From: Anita Gardner
Sent: 21 March 2018 12:52
To: Karen Parsons
Subject: FW: Planning Consultation on: FG/206/17/PL

Comments from Greenspace

Further to the submission of Landscape Plan A-17-31-FW dwg 200-06 Rev A, I can comment as follows.

Description of Works: Installation of a Six Pump (12 Filling Position)
Petrol Filling station, Drive-to- Pay Kiosk &
associated works including Jet Wash, Air/ Water
Services & Vacuum Equipment

1731FW CA S0 00 00 A 200_06 S4 B Landscape Plan

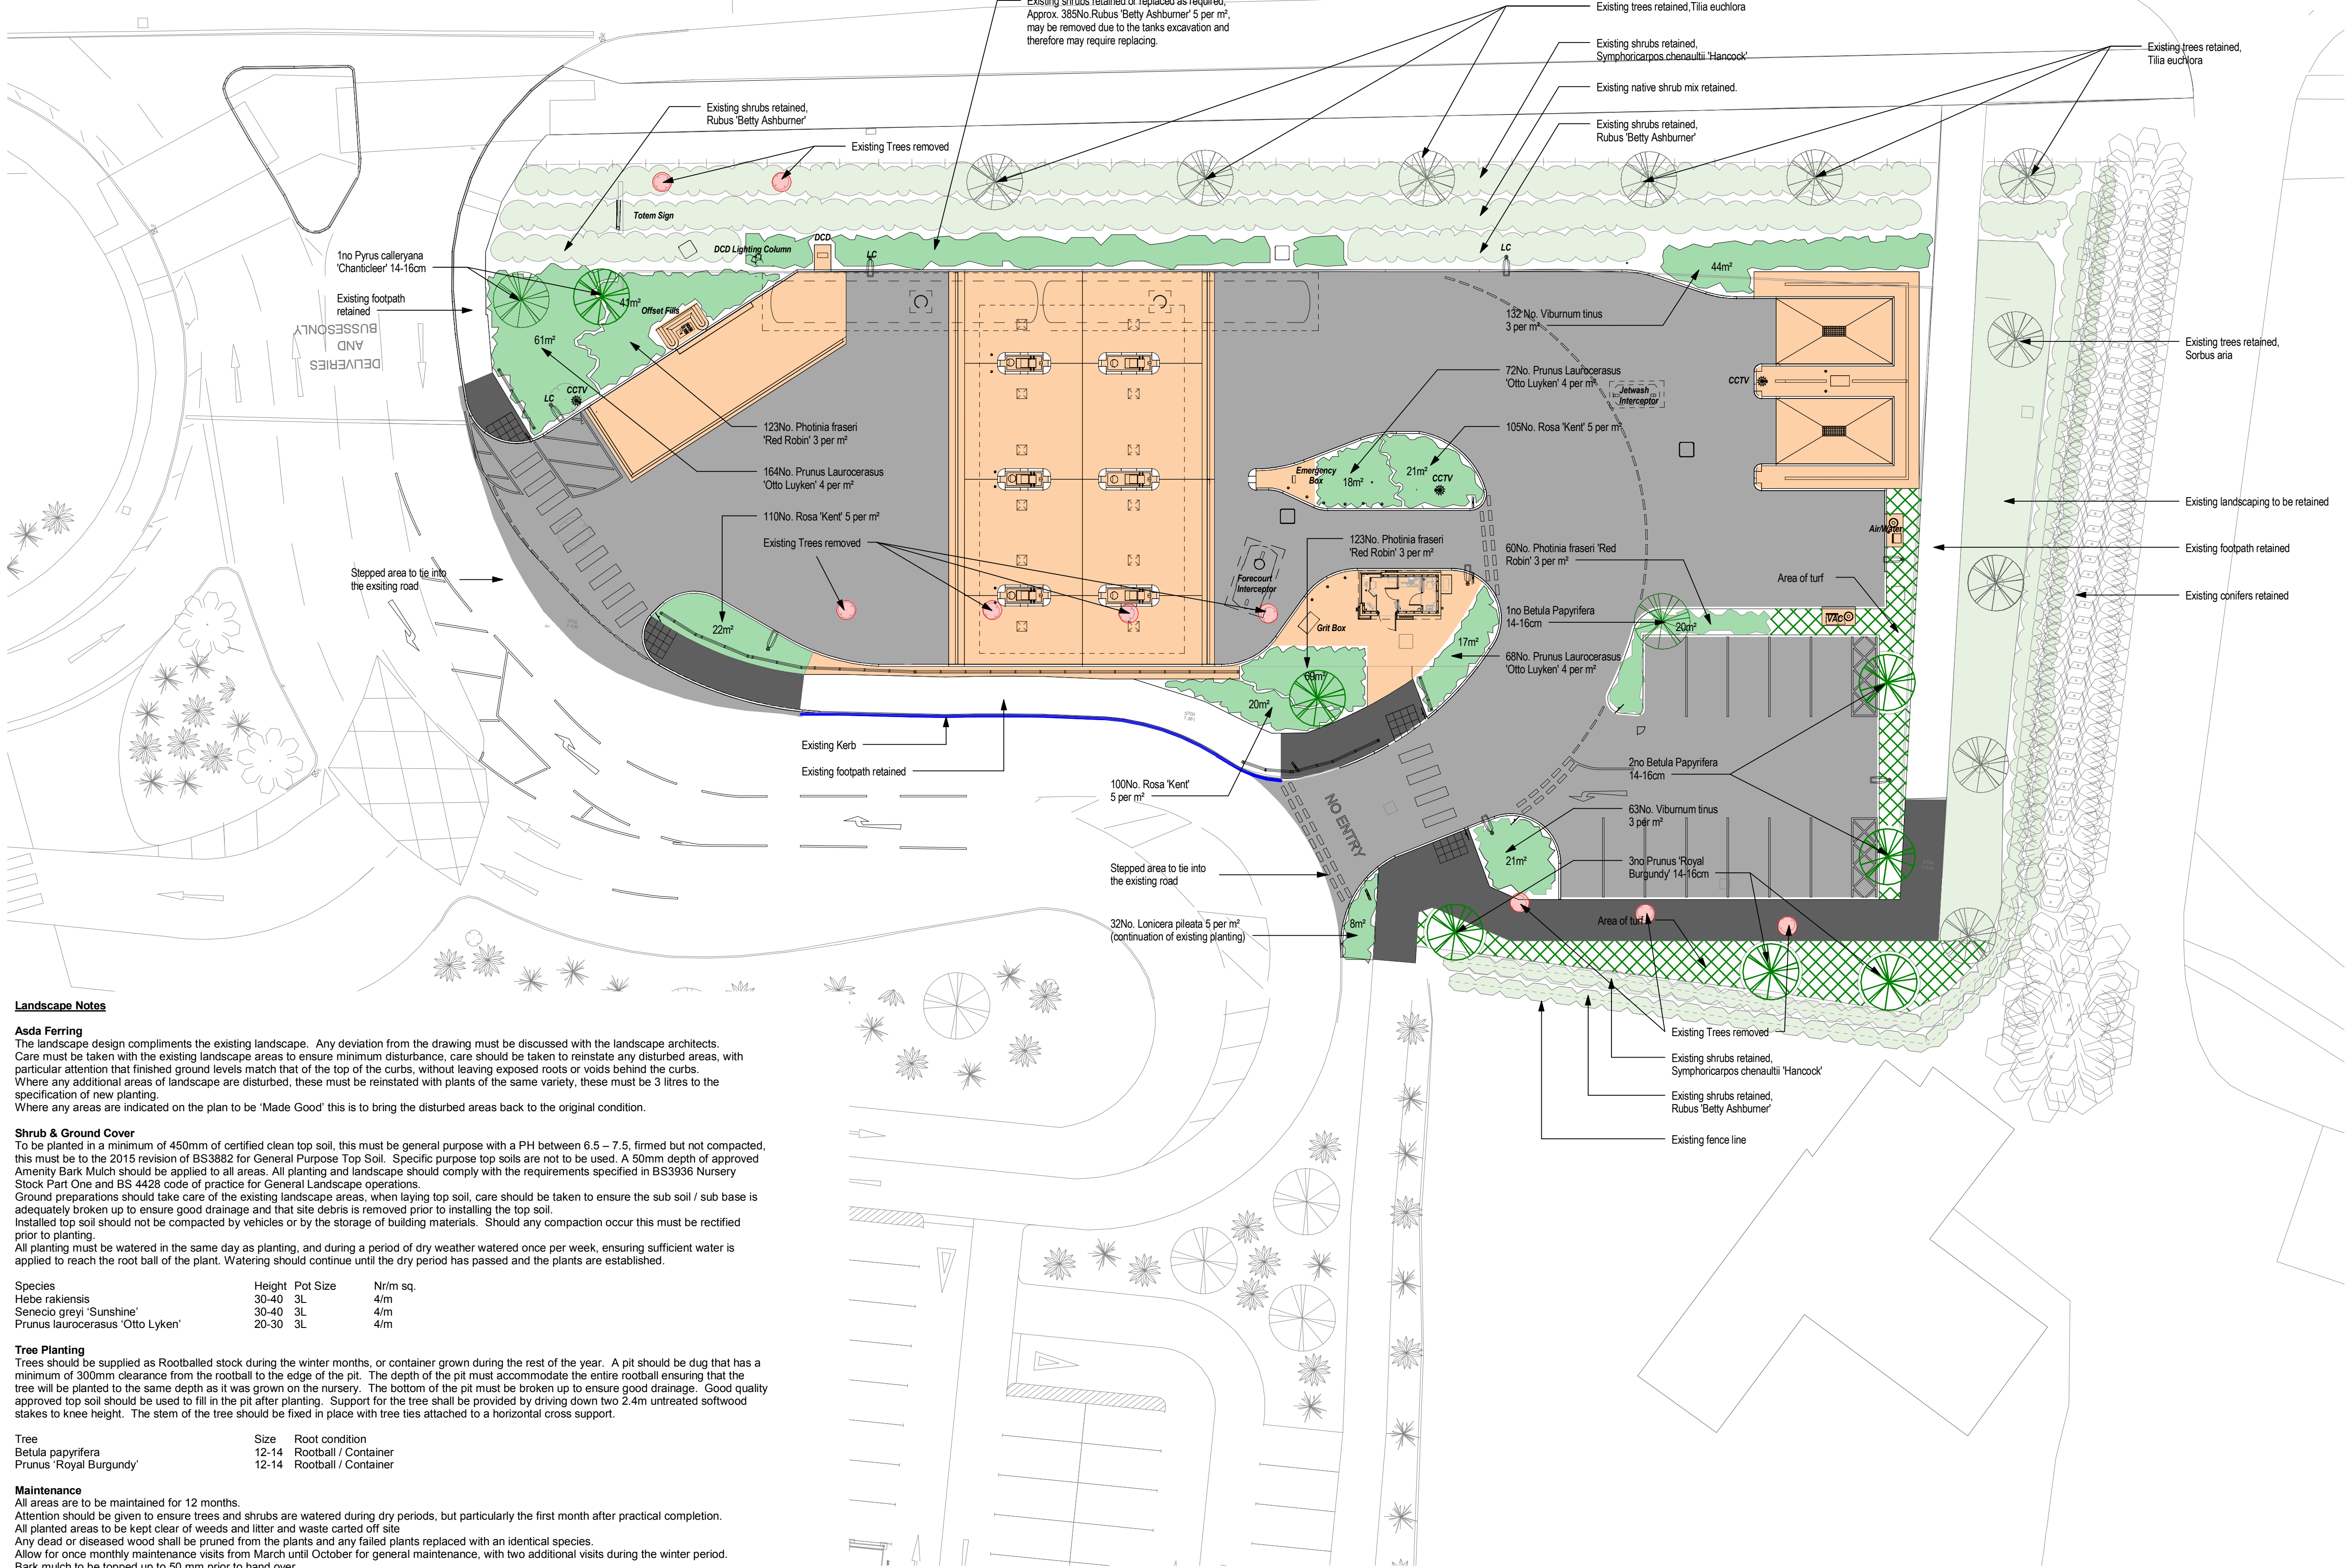
The proposed site contains an existing and establishing planting scheme implemented at the time of the ASDA store. This planting is establishing well and contains a mix of trees and shrubs both evergreen and deciduous which in context are adding value to the location. This planting appears to have been disregarded within the proposals in particular the hedging to the south eastern boundary which is to be lost to a pathway with the proposals as shown. Juvenile yet establishing trees also in this location and within an existing central island planting bed will also be lost if the proposals go ahead as detailed.

The proposed planting scheme contains plant species which would be considered more ground cover ie Hebe and Senecio rather than adding landscape structure planting, without any screening value. The trees indicated are also at a smaller size at 12-14cm girth to those in existence.

My recommendation is that the proposed landscape scheme is inadequate regarding what would need to be removed in order to implement these proposals. The planting proposals are not replacing on a like for like basis and is providing no mitigation to compensate for the new use of this area. These proposals will cause impact to local residents and will also be seen from the wider area particularly from the SDNP to the north. Further landscape detail should be considered and incorporated into this proposal in order for the landscape value and the impact on its surrounds not to be compromised.

I would recommend an objection on landscape grounds to the proposals at present which could be overcome with a more thoughtful and complete landscape proposal. I would recommend that further landscape detail is submitted for approval or conditioned along with any decision.

I can confirm that we will respond to the Landscape Officer's concerns through the submission of a revised landscaping plan. Furthermore, our noise consultant is also due to respond to the comments of the EHO.
